Town and Country Planning Act 1990 Refusal of Planning Permission

Reference: H16-0131-15 Received: 18th February 2015 Type: FULL

Description: Proposed dwelling
Location : River Bank Spalding

Scale 1:200 1:2500	Drawing No. 1415-02
Date. MAY 74	Drawn. J.C.

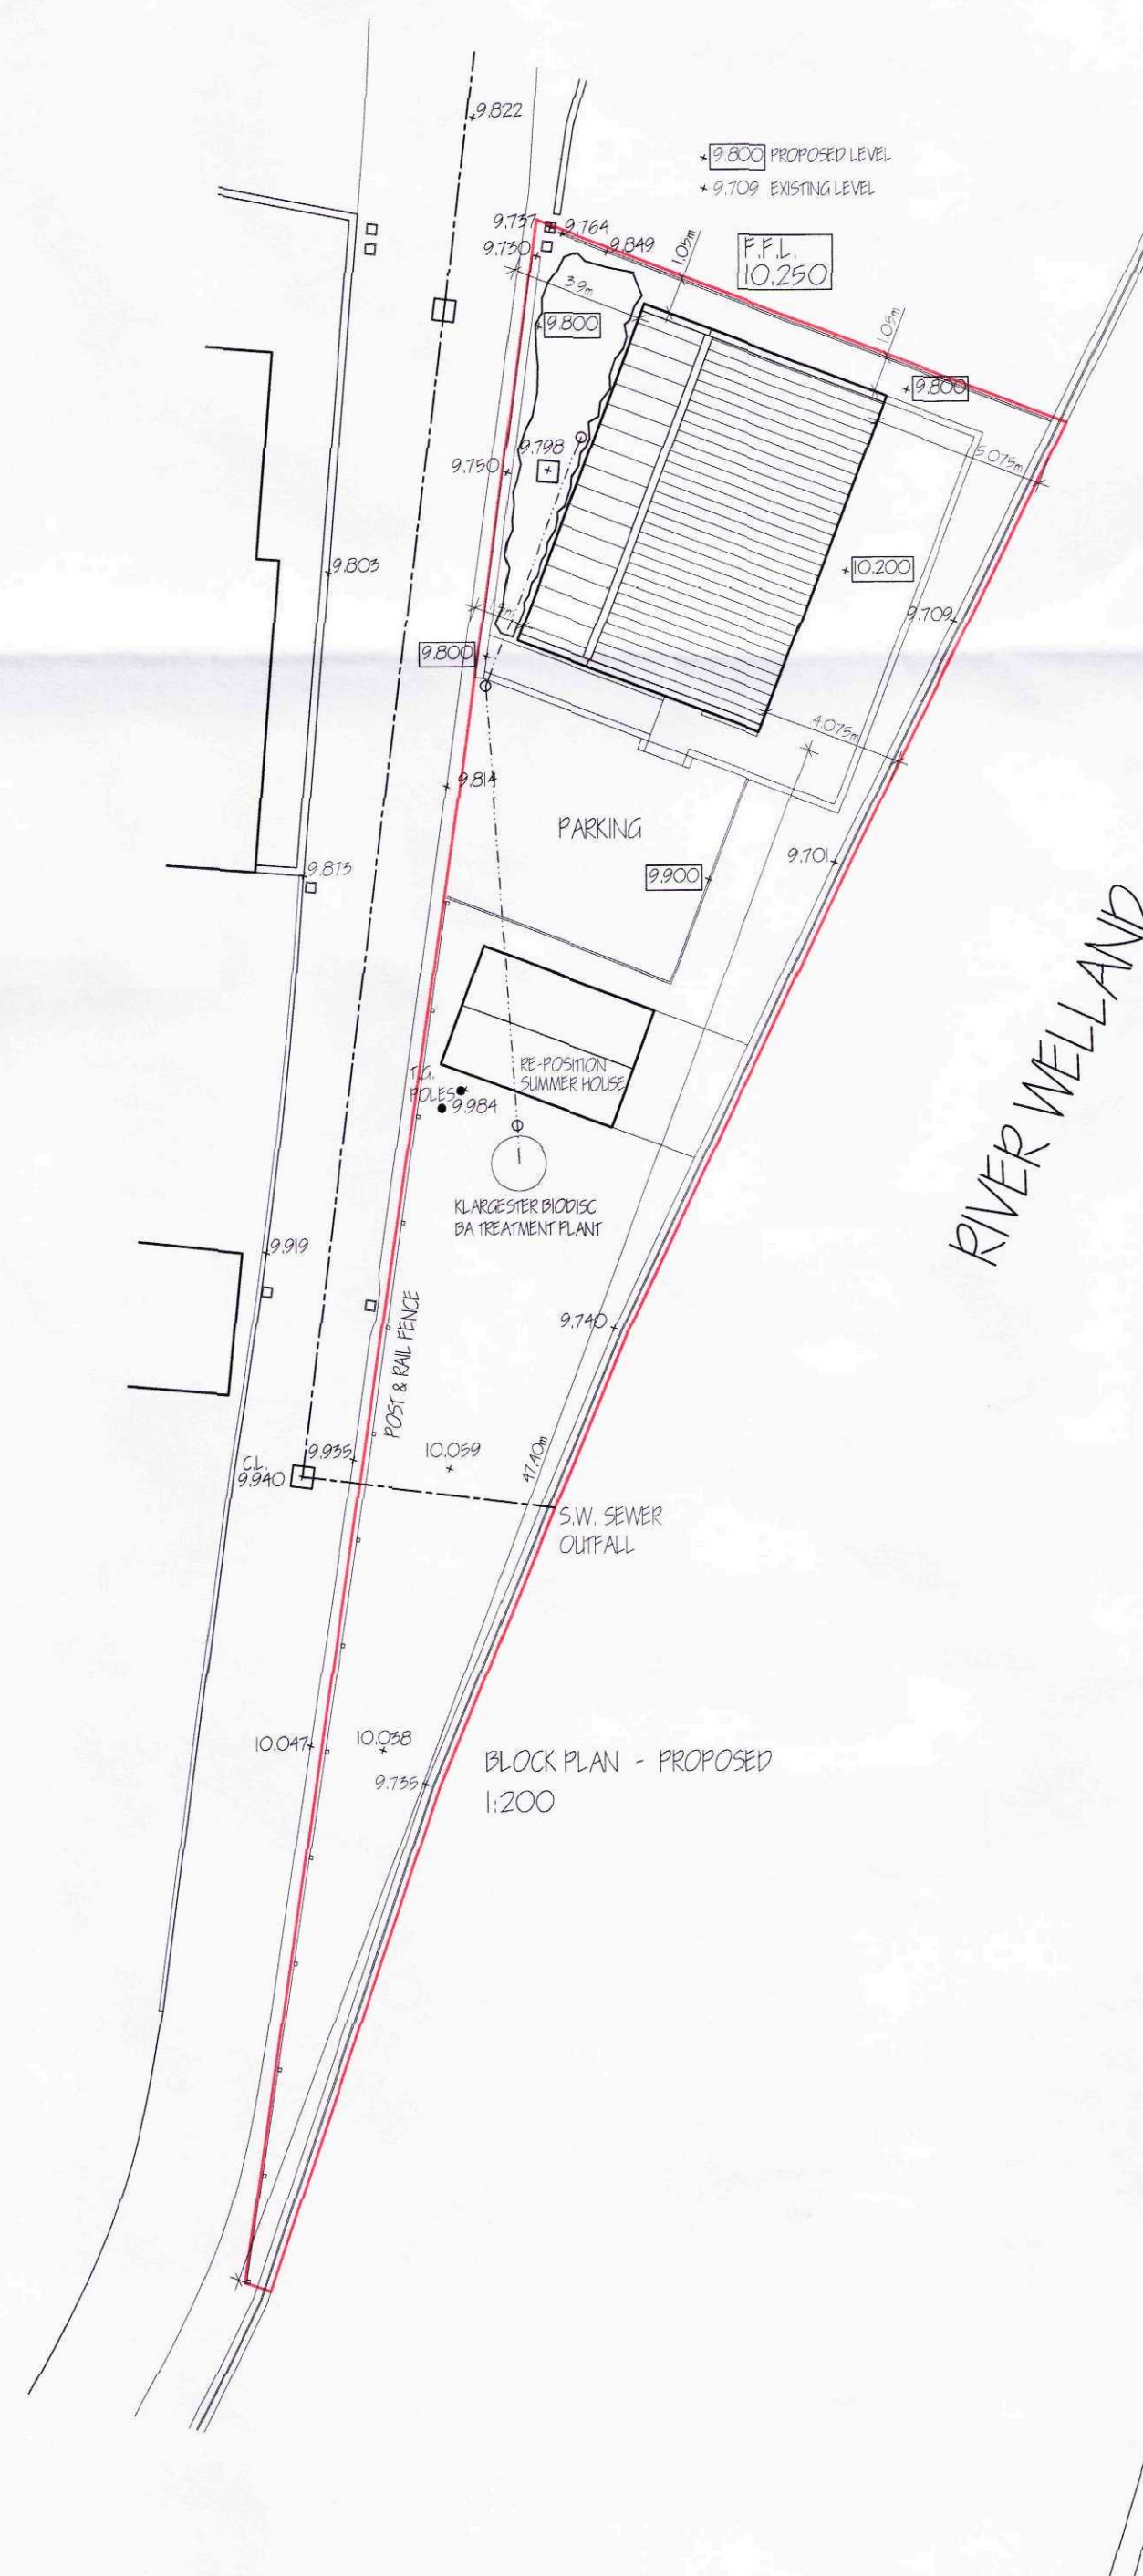
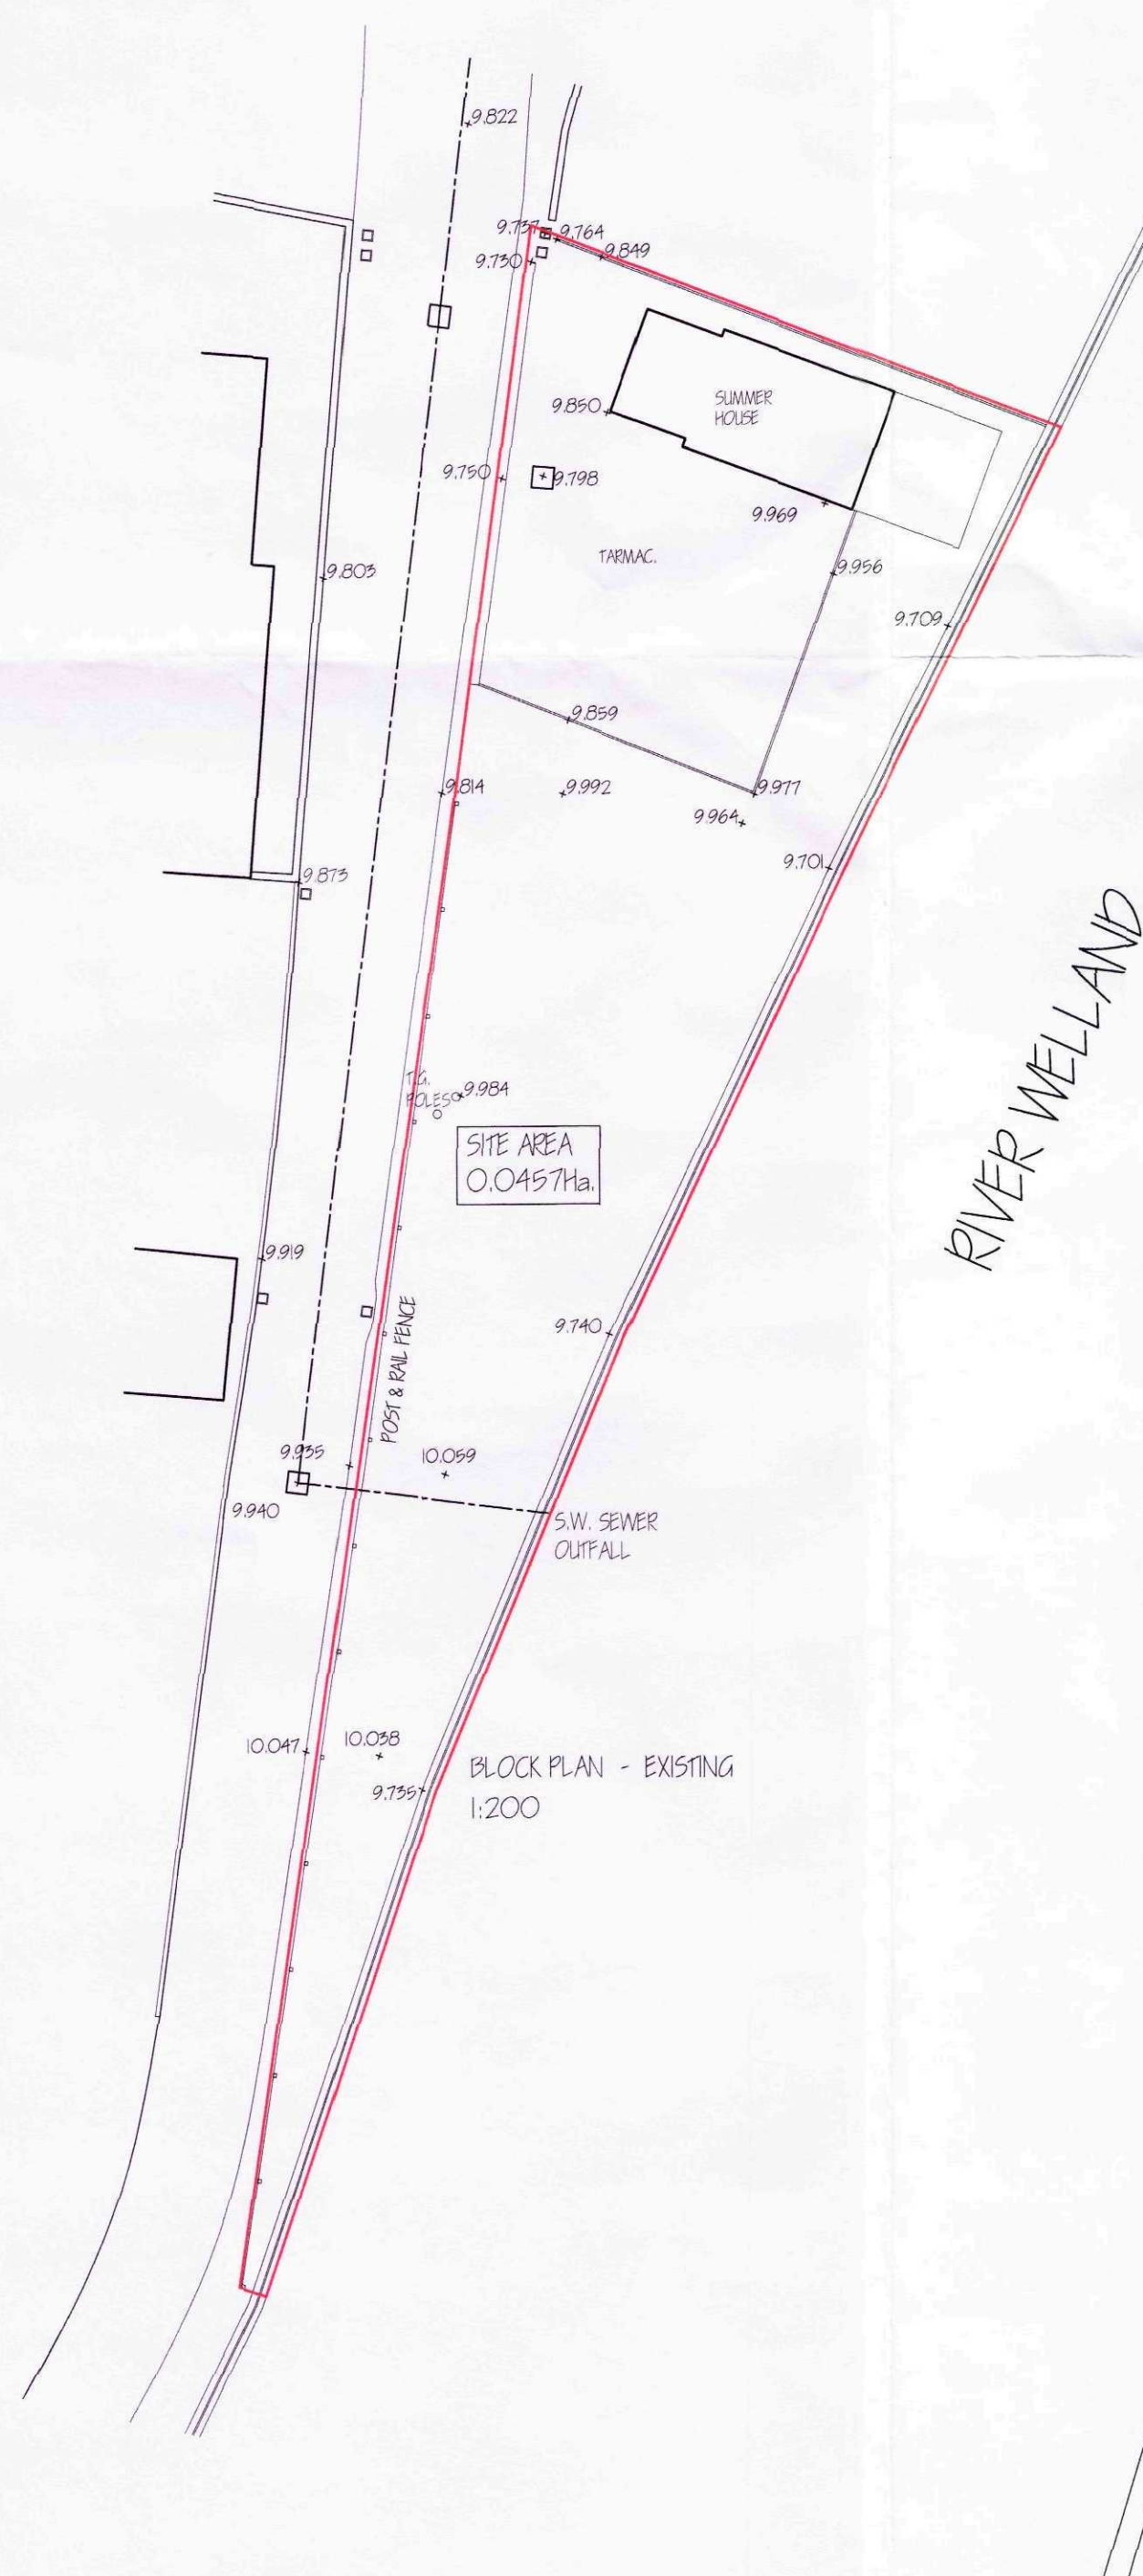
- 1 By virtue of its location and its two storey design, the proposed house would unacceptably threaten the privacy of habitable room windows within the nearby number 9 River Bank, some 8 to 9 metres distant. Furthermore, any active use of the proposed garden area including re-erection of the current "summer house" as indicated on the submitted Block Plan would have an unacceptable and un-neighbourly impact upon the character and appearance of the locality as a whole, notably including numbers 9, 10 and 11 River Bank. The proposed dwelling would therefore be contrary to the objectives of Policy SG14 of the South Holland Local Plan and Section 7 of the National Planning Policy Framework.
